FULL

Reference:	H05-0861-25	Date of Decision:	10th November 2025
Applicant:	Mr A Wright 14 Cross Street Fleet Spalding Lincolnshire PE12 7BD		
Location:	Adjacent To 14 Cross Street Fleet Spalding Lincolnshire		
Description:	Proposed Dwelling

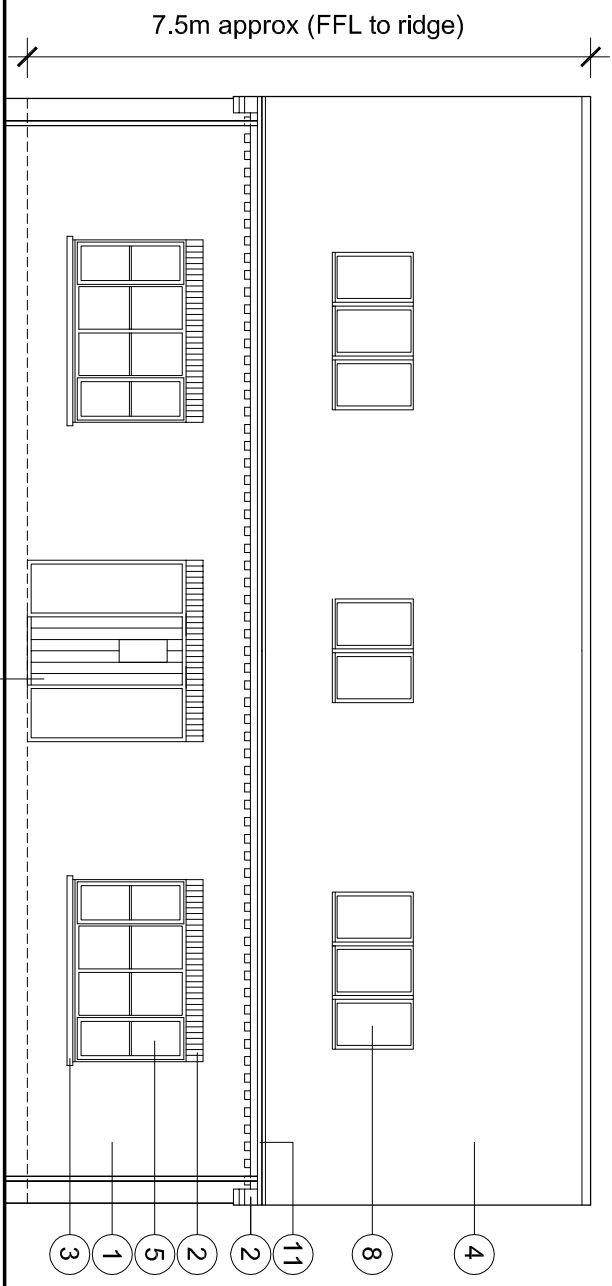
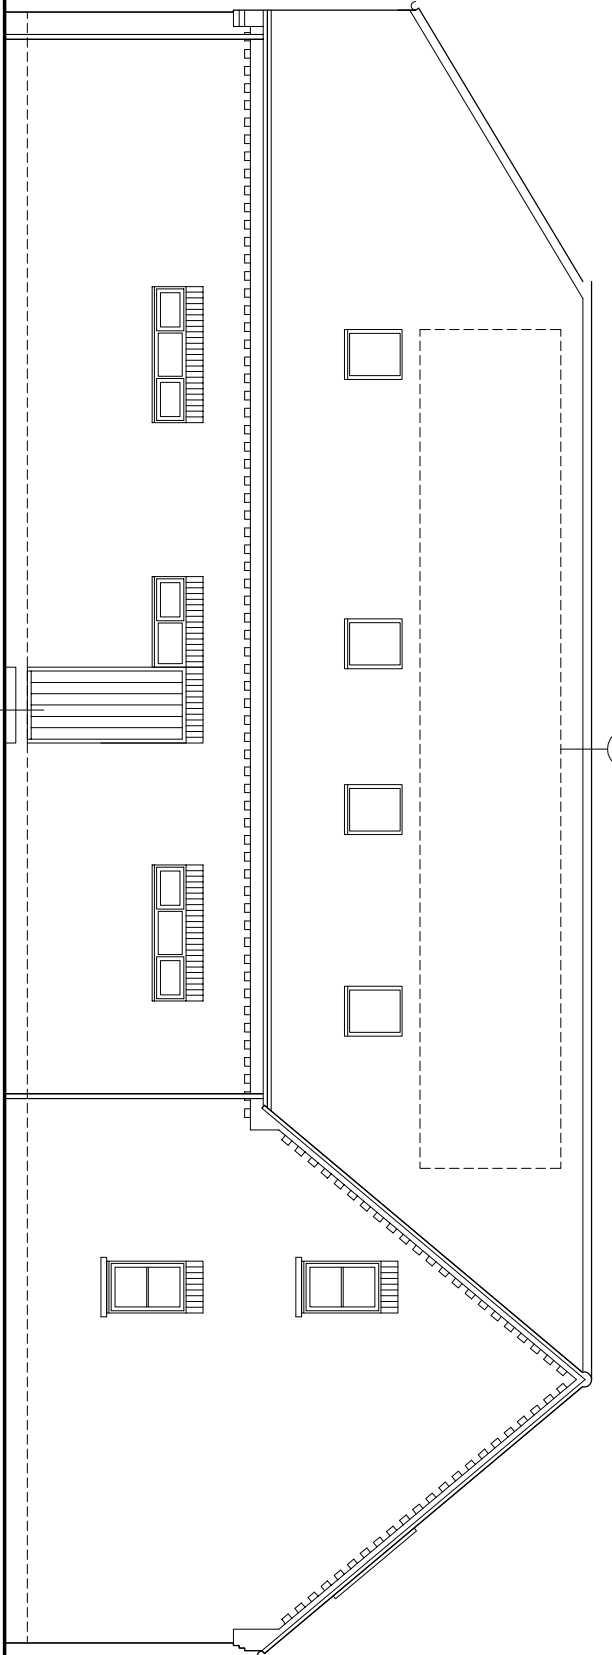
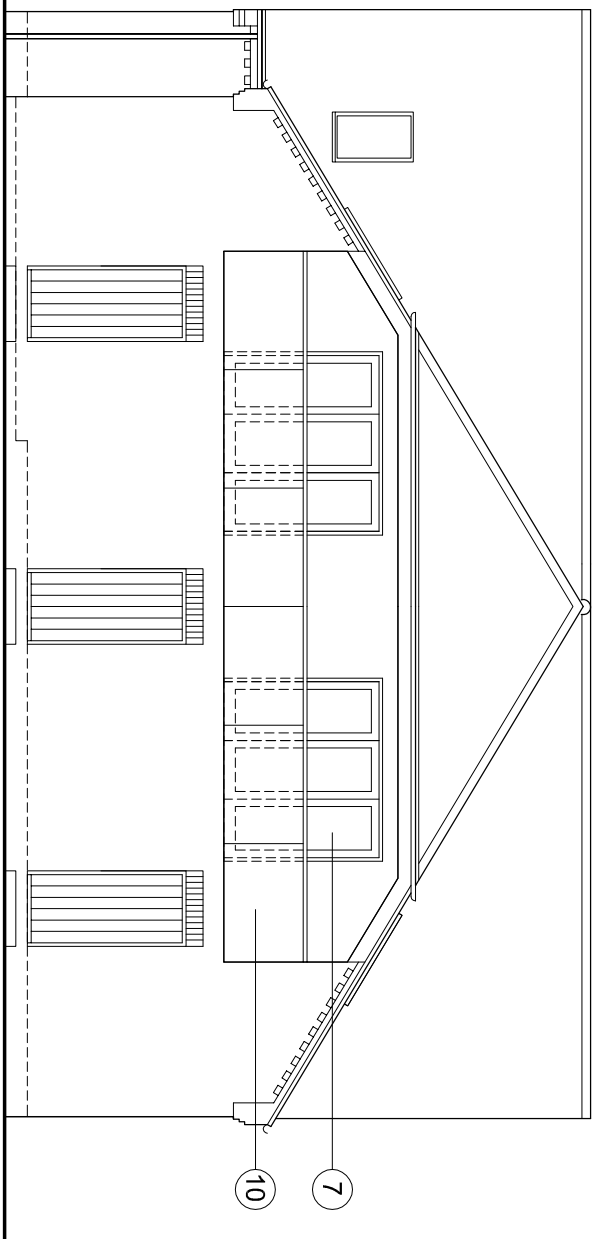
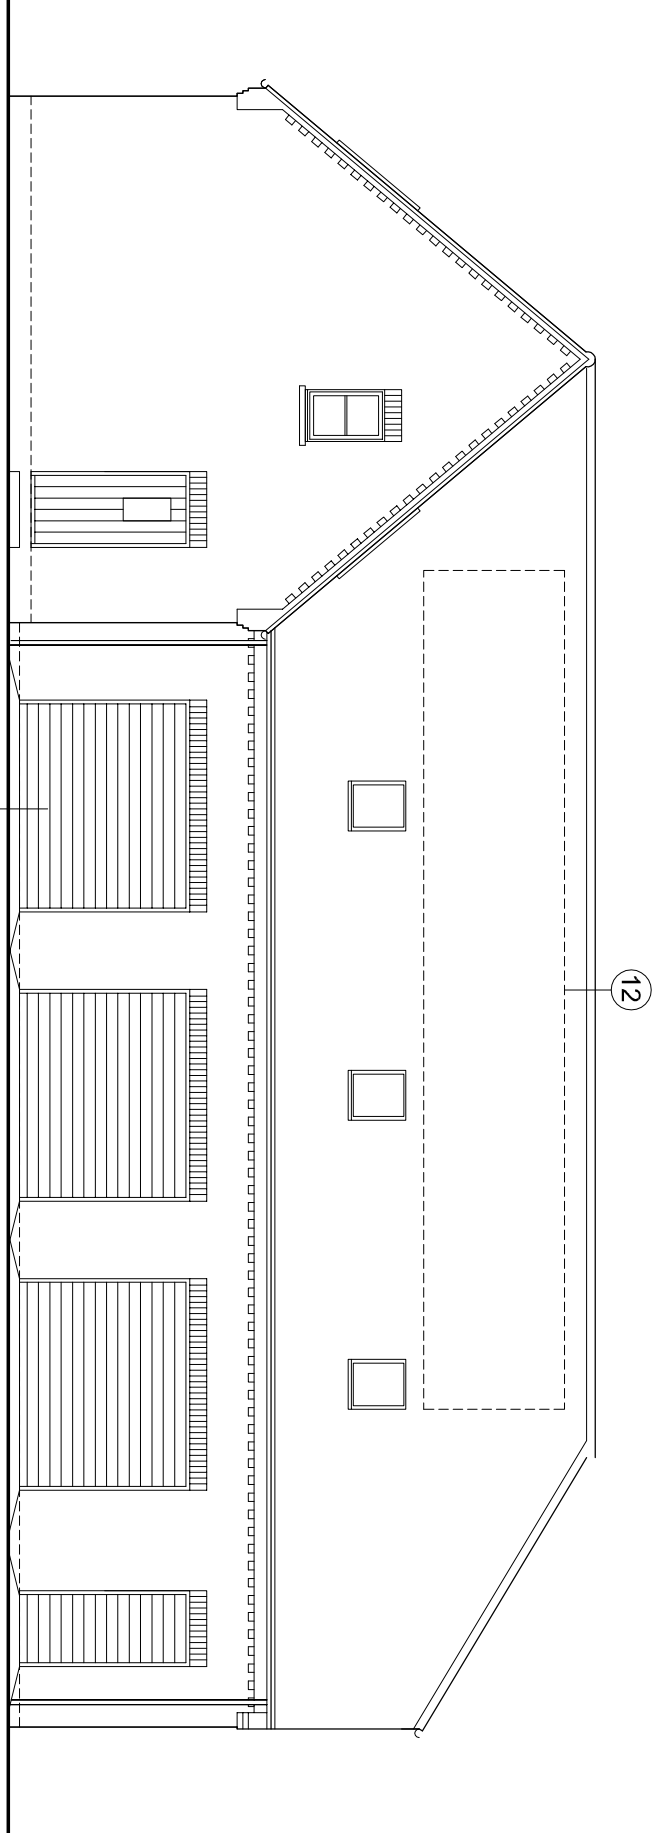
The proposed dwelling would have a height of approximately 7800mm; a scale that is significantly taller than the neighbouring dwellings which comprise heights of 6000mm and 5500mm respectively. The resultant built form, by way of its chalet bungalow design and

The proposed dwelling comprises a resultant height that is no less than that previously refused and dismissed on site, and would retain its unacceptable and incongruous form.

The overall scale of the proposed dwelling, in respect of its mass, bulk and height; coupled with the location of roof windows and their low level within the roofslope on the east and west elevations, are considered to cause opportunities for a loss of privacy to No.14 and No.18 Cross Street, whilst causing an overbearing, oppressive and unacceptable impact.

Proposed Block Plan (1:250)

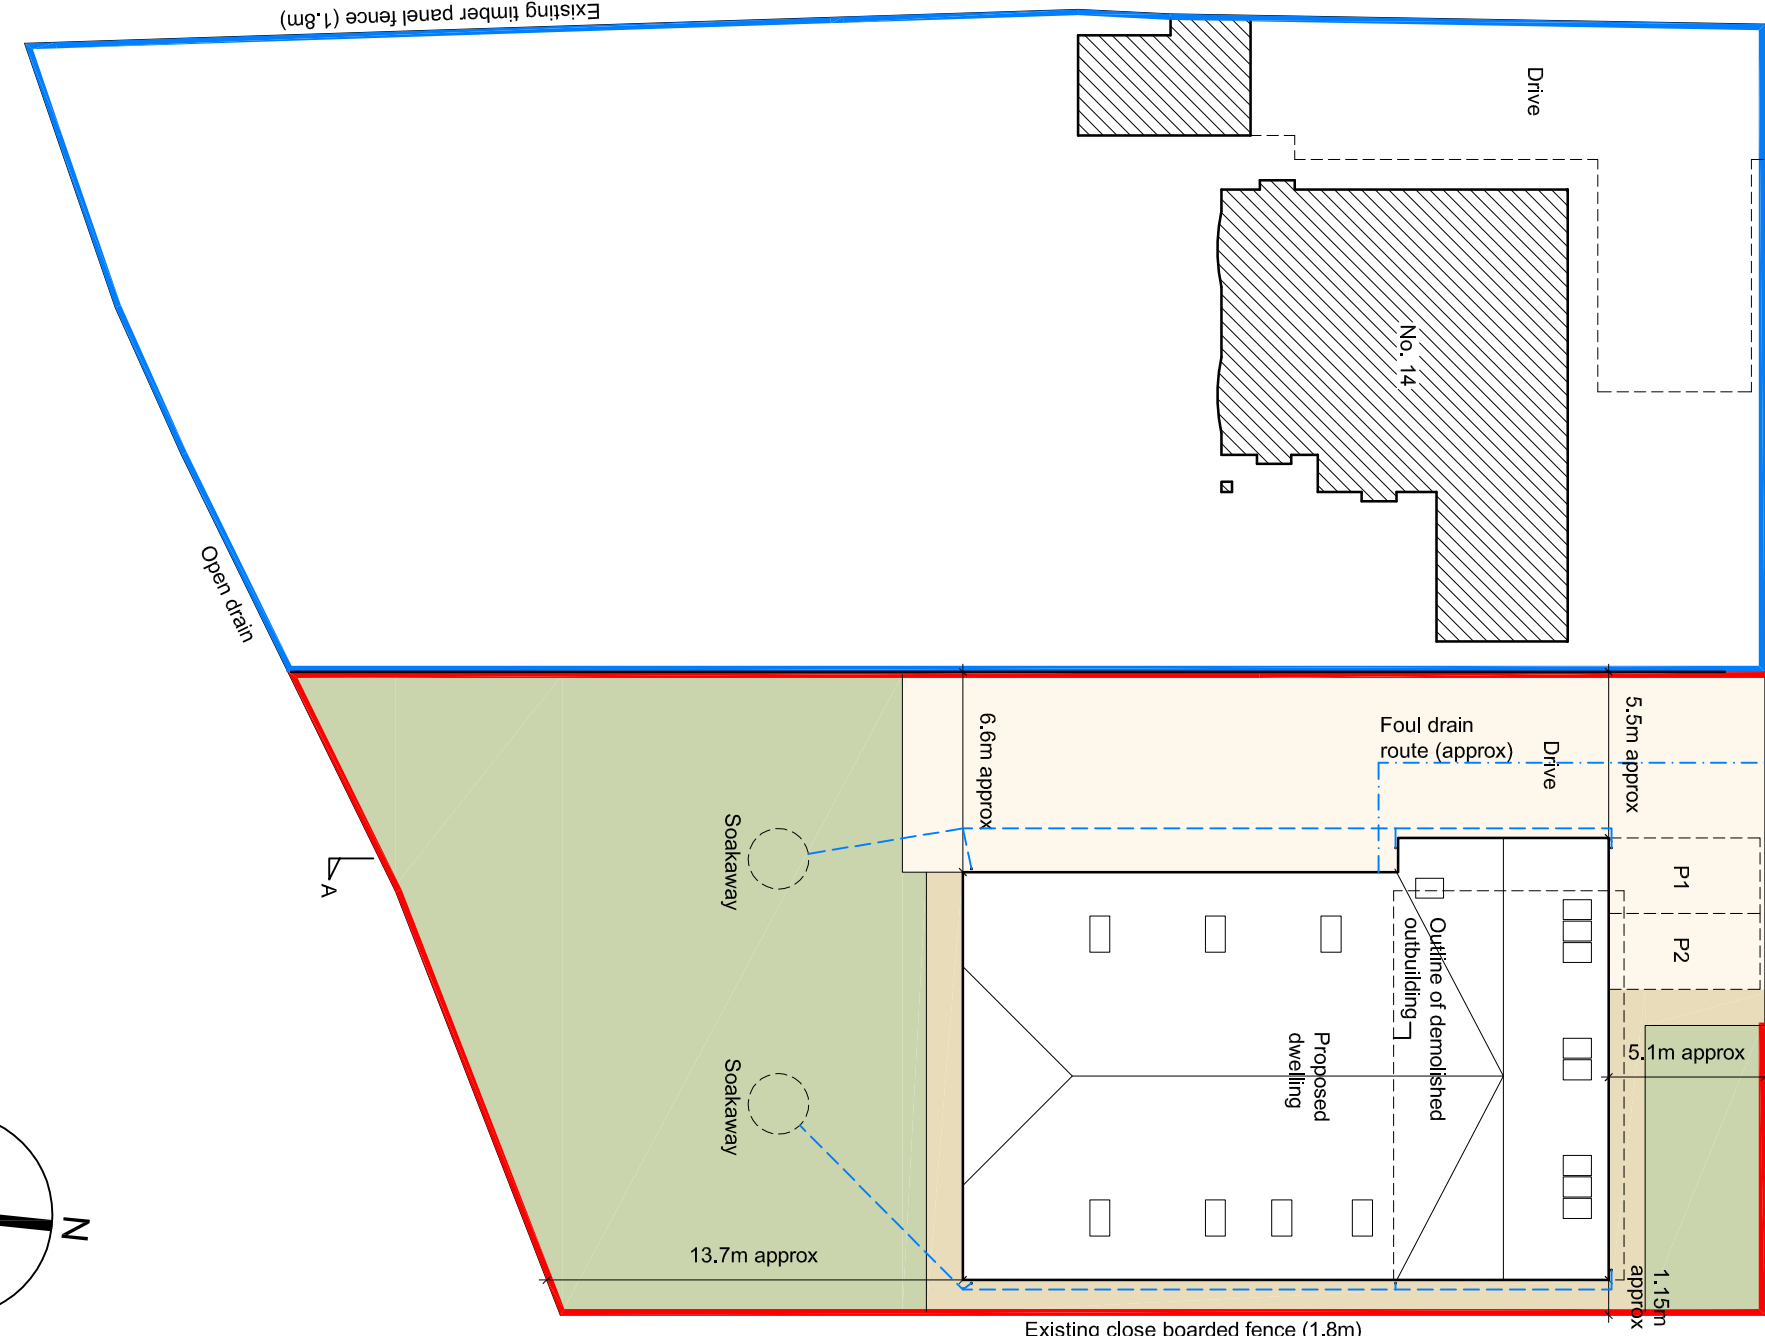
In addition, the proposed dwelling would also extend significantly beyond the existing neighbouring dwelling of No.14. The proposed dwelling would be sited as to provide a similar frontage arrangement to that of No.14; however, would extend notably beyond the front of No.18, whilst comprising an extensive built form as to extend beyond the rear of this neighbouring dwelling also. This further emphasises the significant mass and bulk of the proposed development, which appears incongruous with the wider area.
